Harnett County

Permit Number: BCOM2603-0001

Description: 11750 sqft. JWR Ventures Manufacturing Building

LIST OF REVIEWS

UL #U419

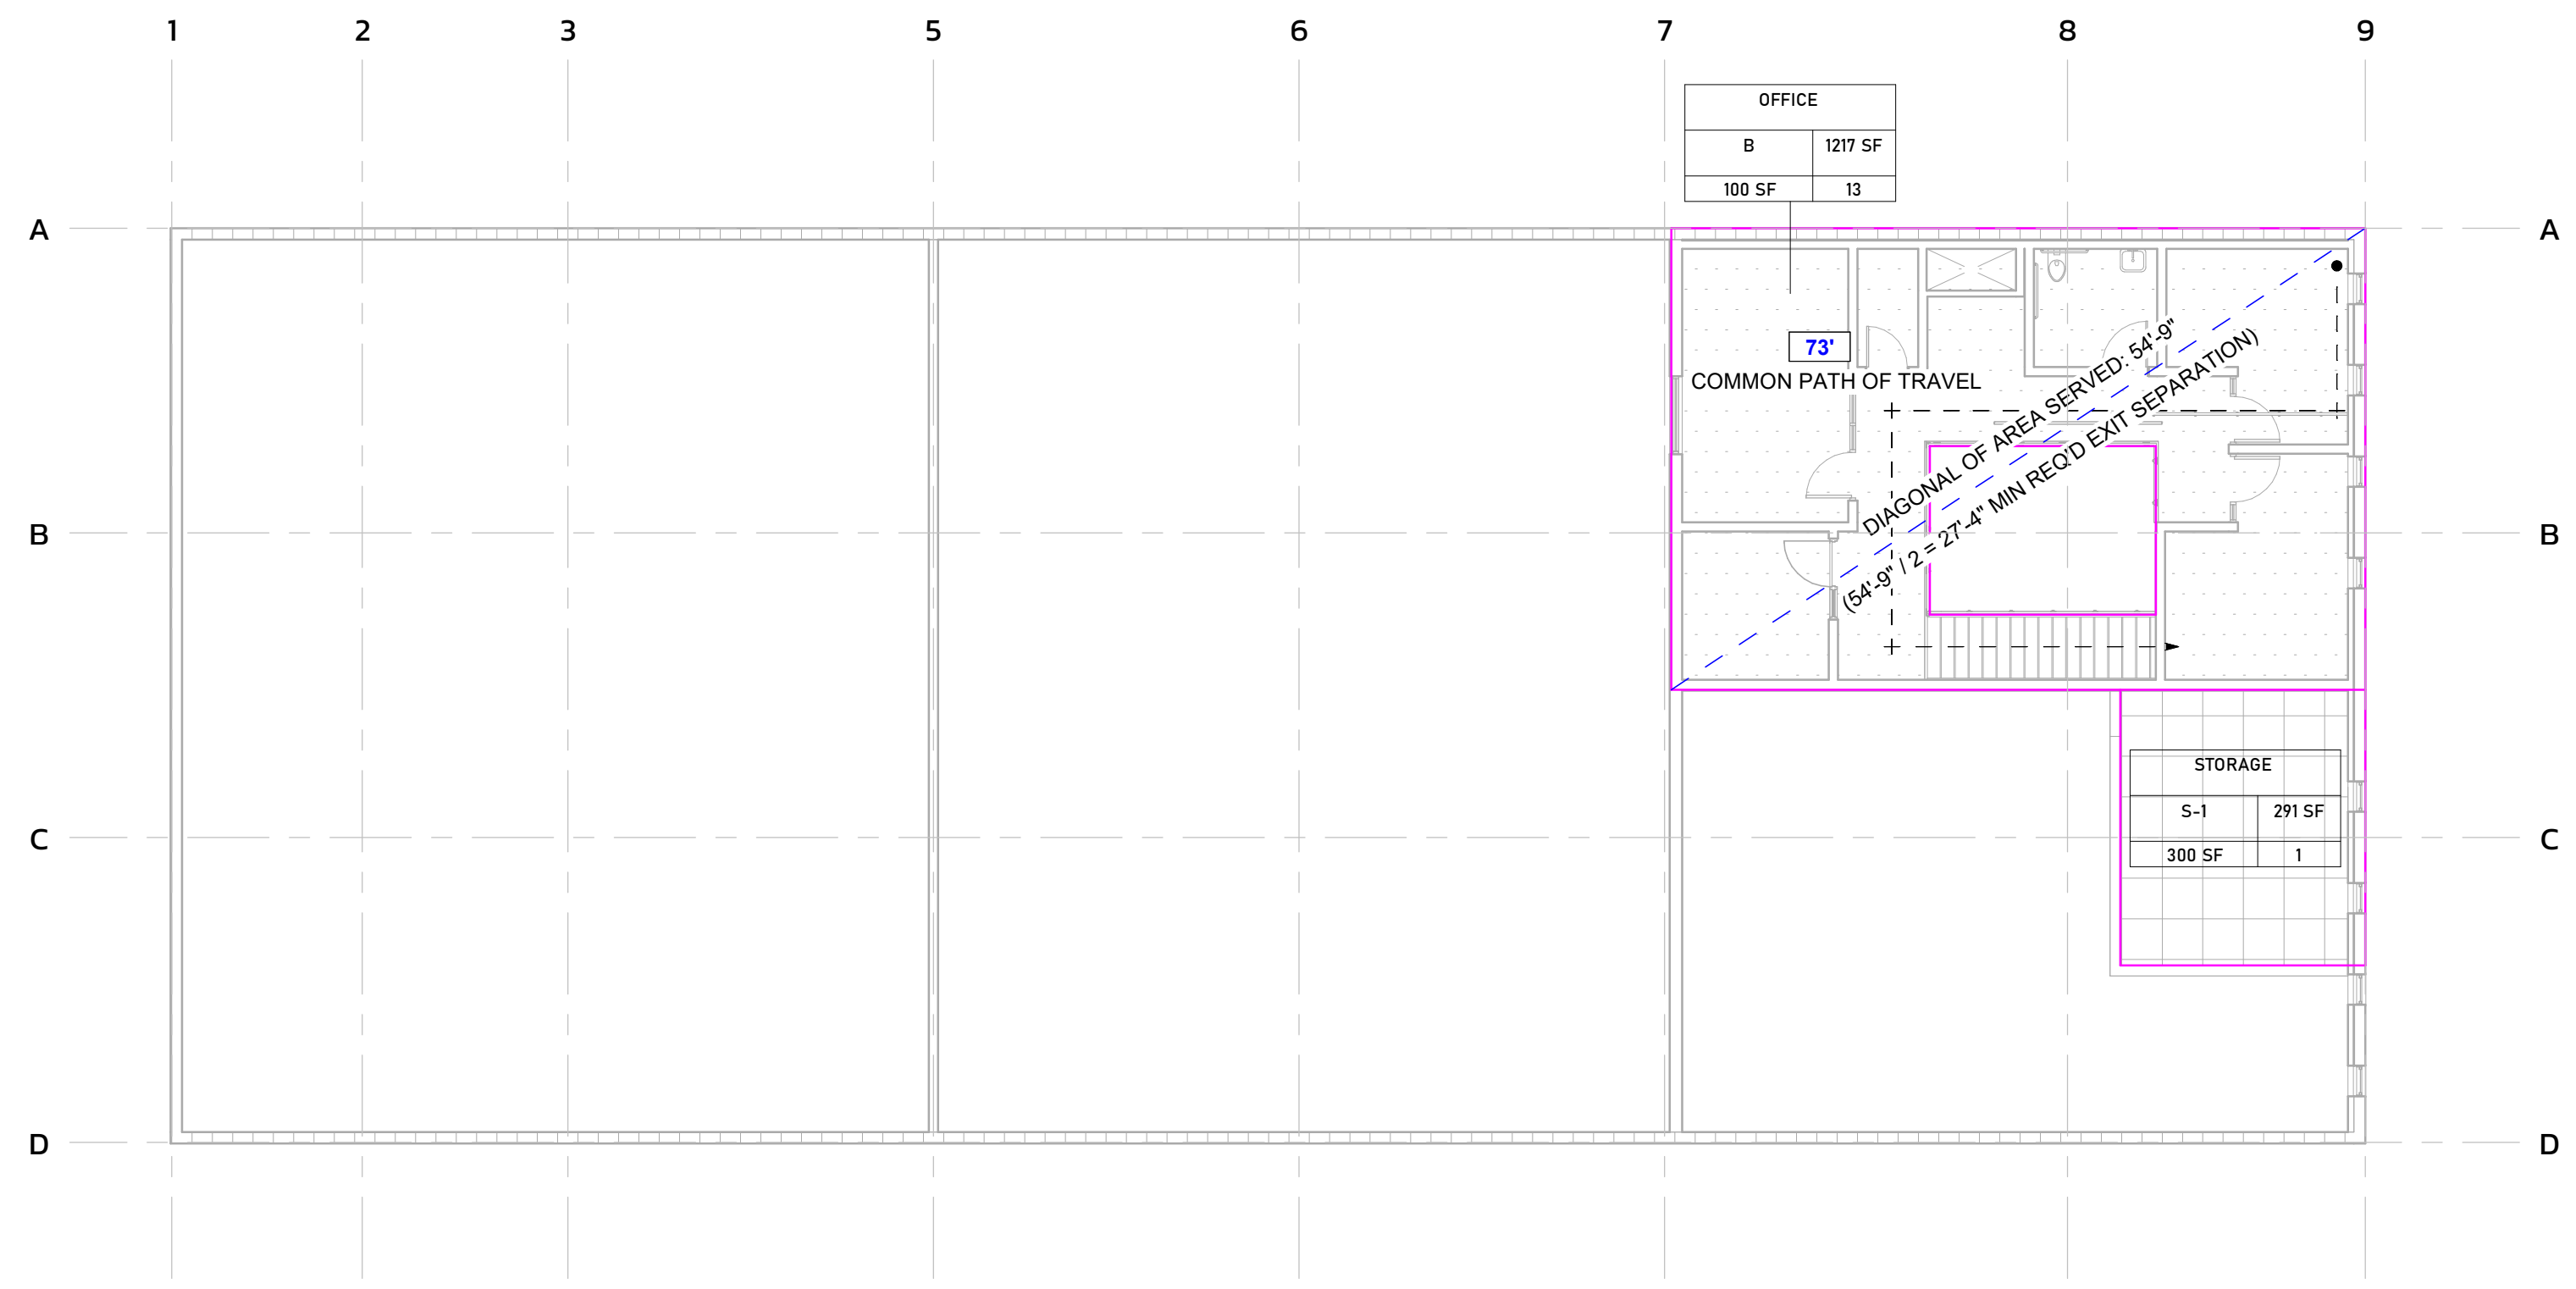
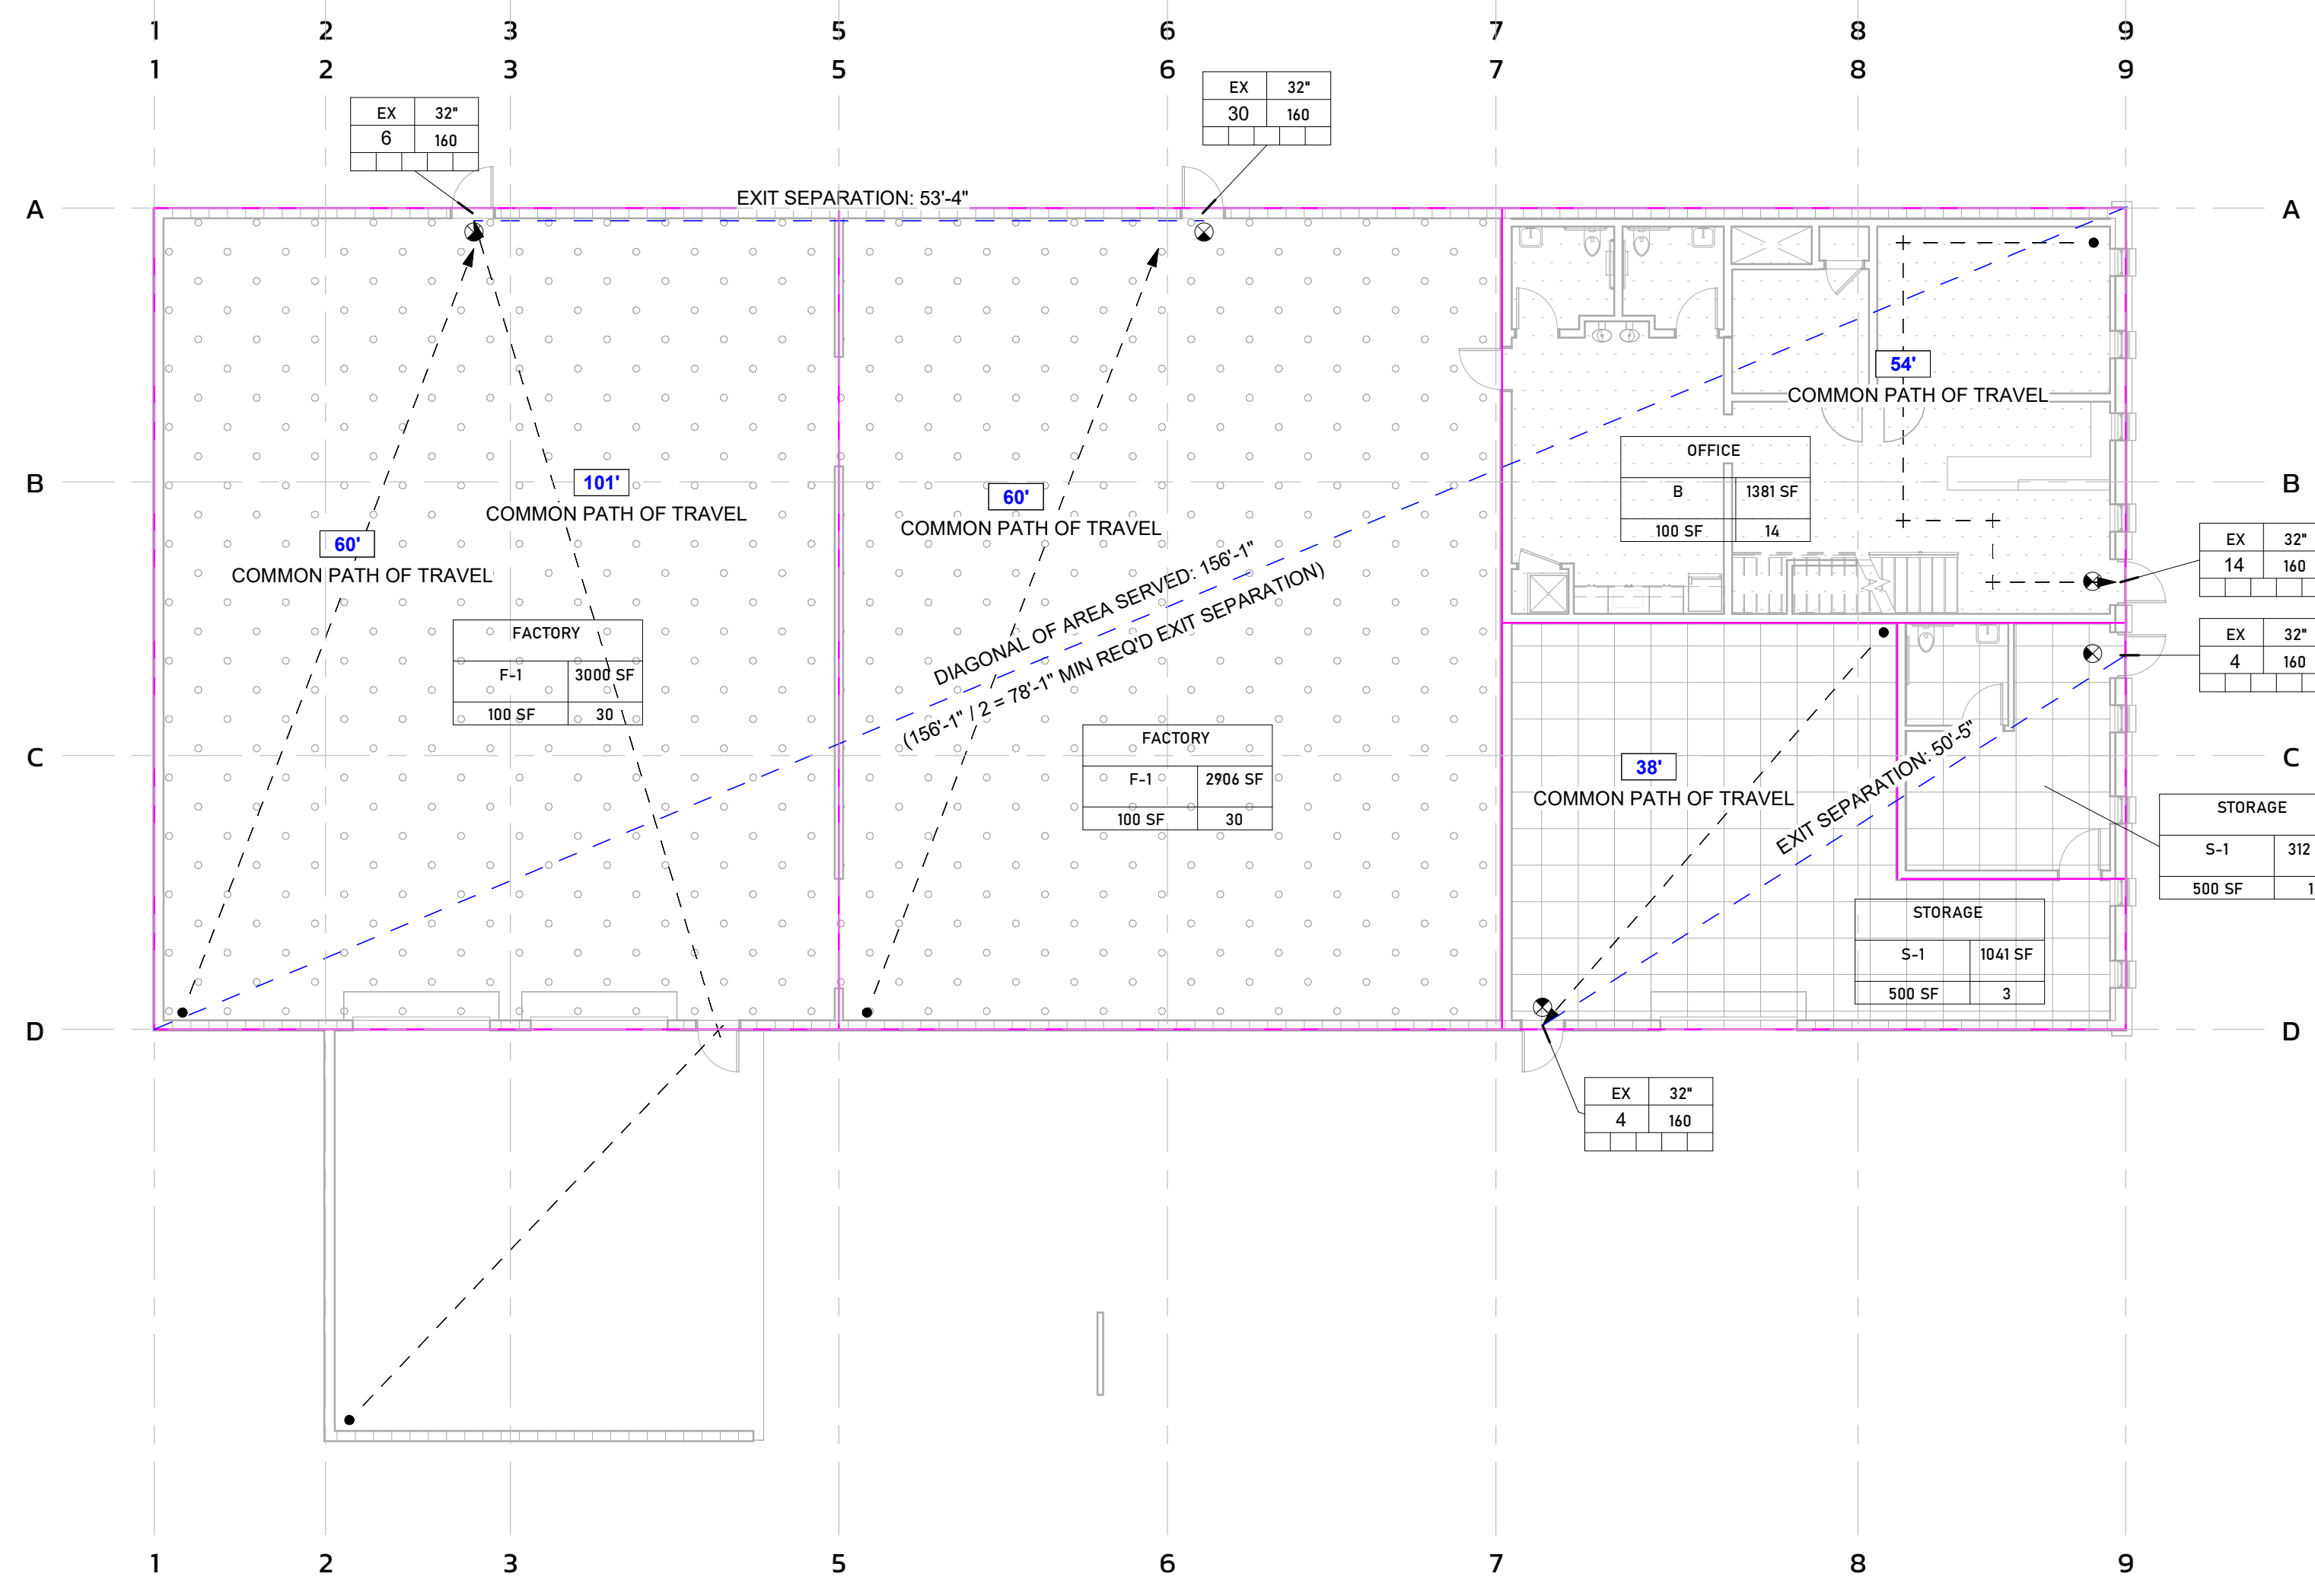
1. Provide information on floor sheathing detail 6 S4.1 penetrating 2 hour wall. 2. Provide information on electrical installation of devices in 3 hour wall. 714.3.2 allows installation in 2 hour wall max. 3. Provide UL details of through penetrations to be used on 3 hour wall for all trades.
